**Re: Lot 11 Block 9 Unit 18 Volcano Cliffs SAD 228
6524 Papagayo Rd. NW
G&D Plan Date: 5/12/2020 (D10D003I11)
Pad Certification Date: 6/30/2020
CO Certification Date: 9/29/2022**

Based on the Certification received on 9/22/2022, the site is not acceptable for release of Certificate of Occupancy by Hydrology until the comments are addressed.

Grading and Drainage Plan

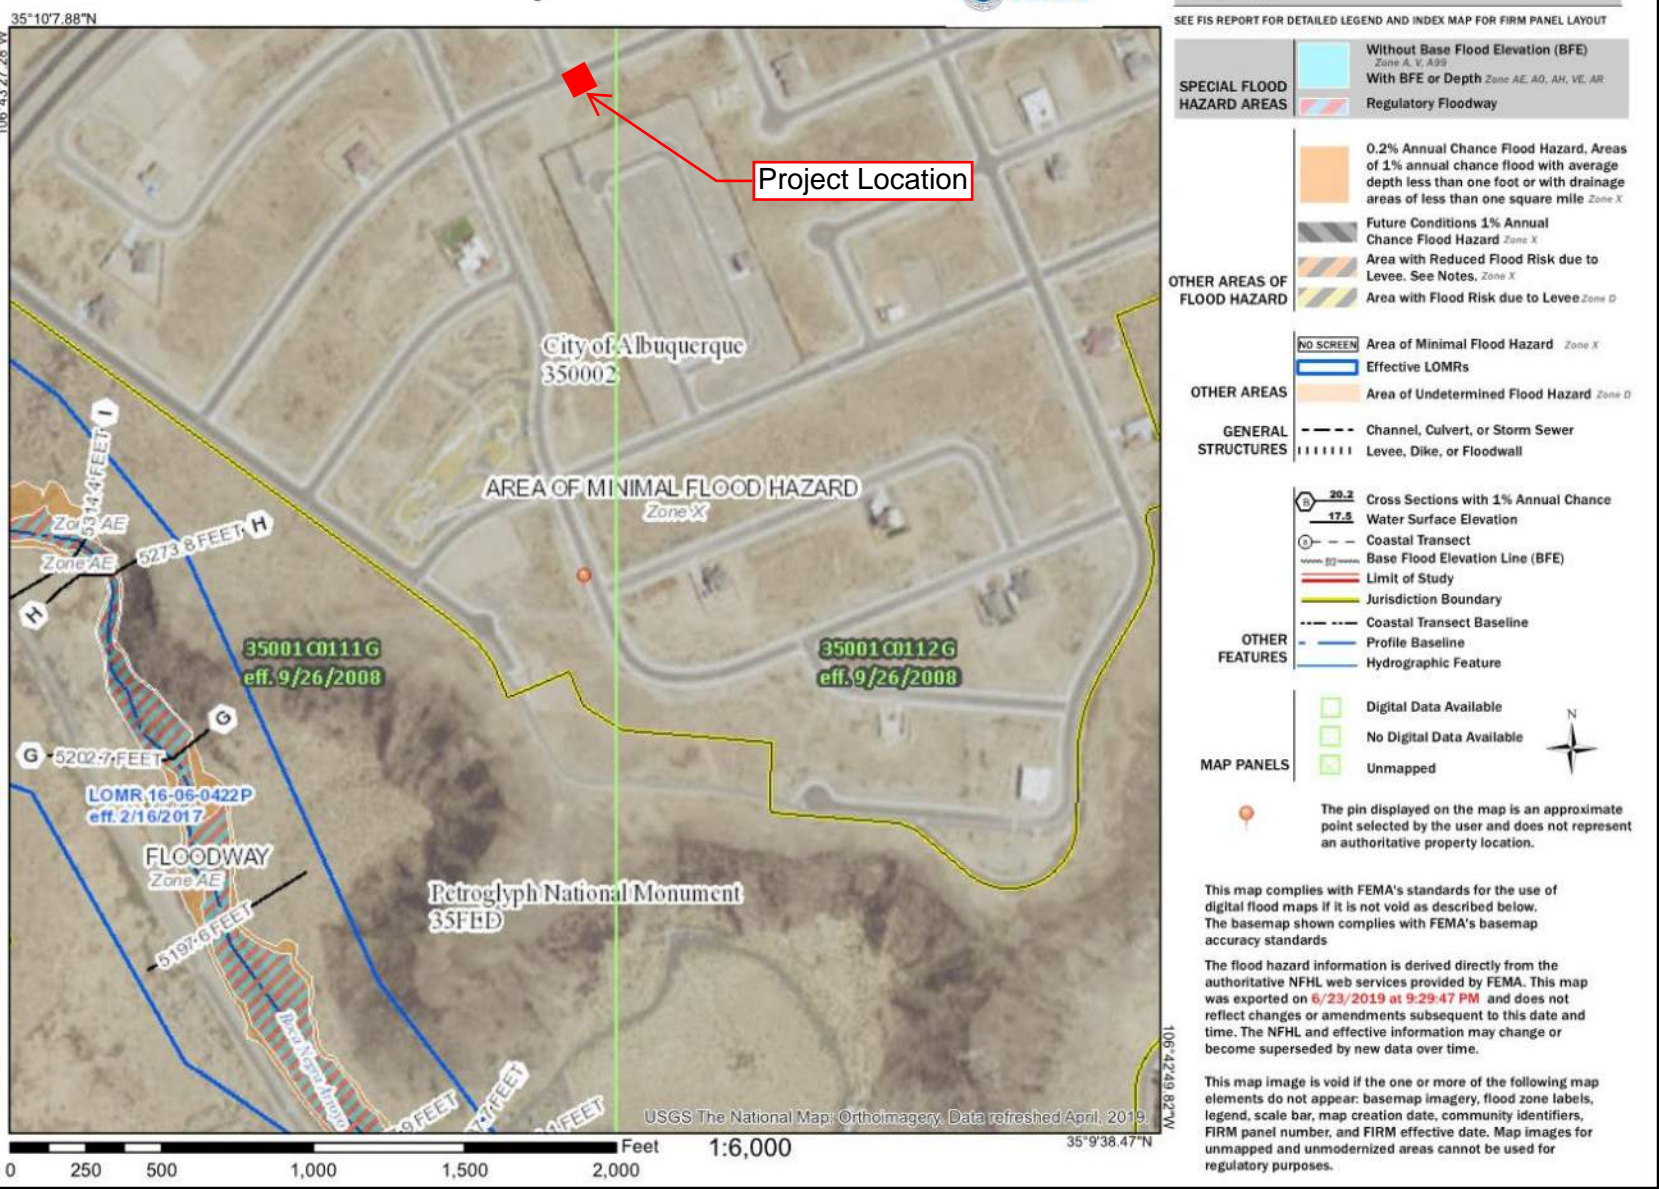
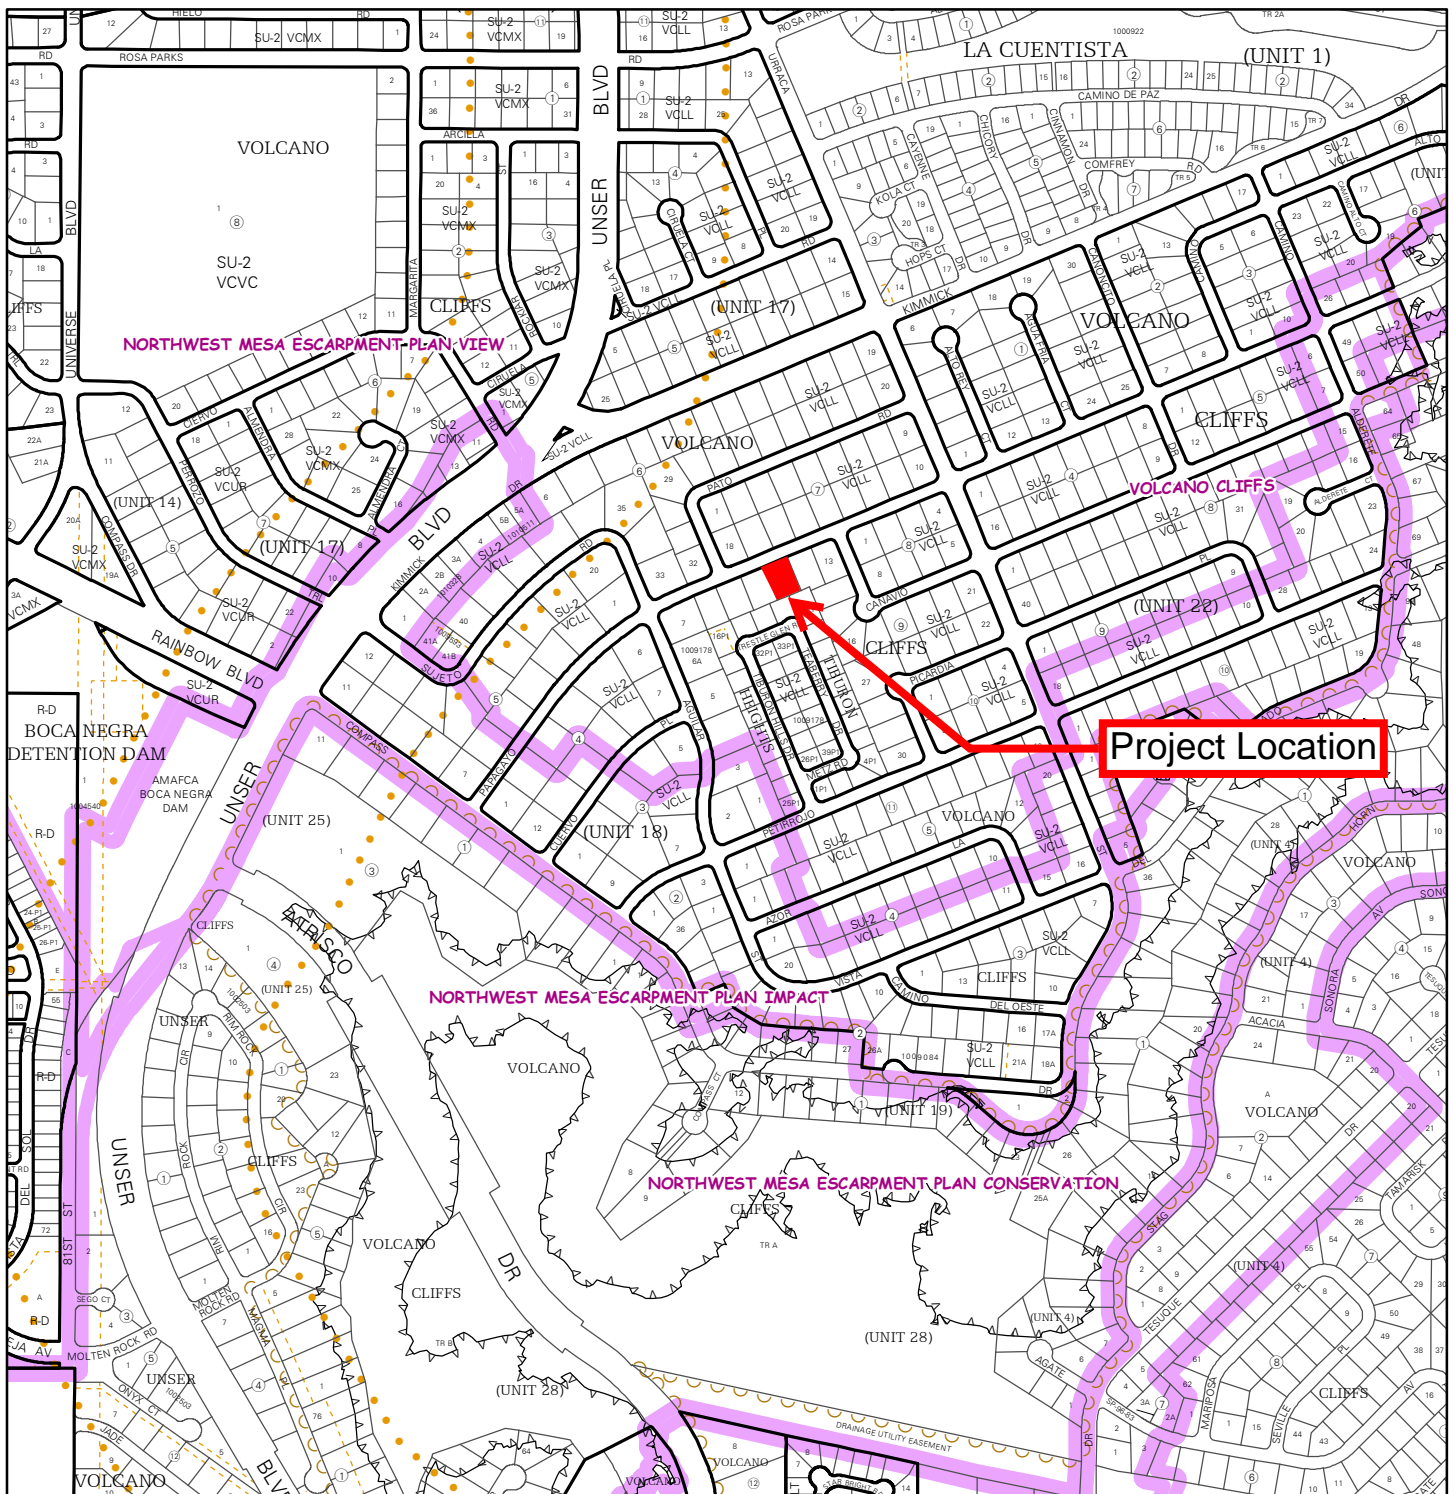
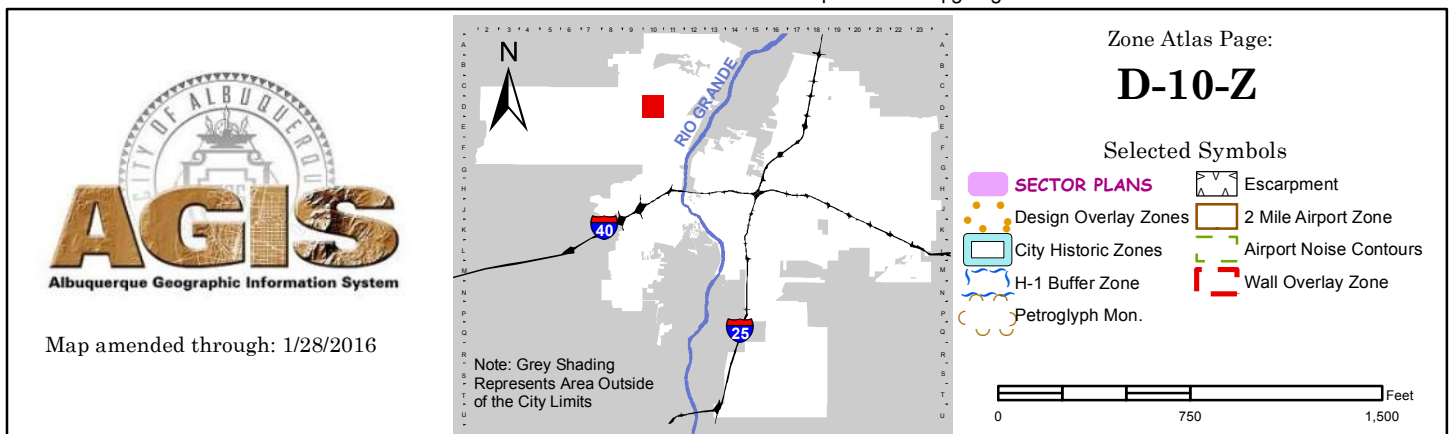
- Provide swales on the rear yard and the side yards by the cmu walls. All the flows from the roof are putting pressure on the cmu walls, this is not allowed.
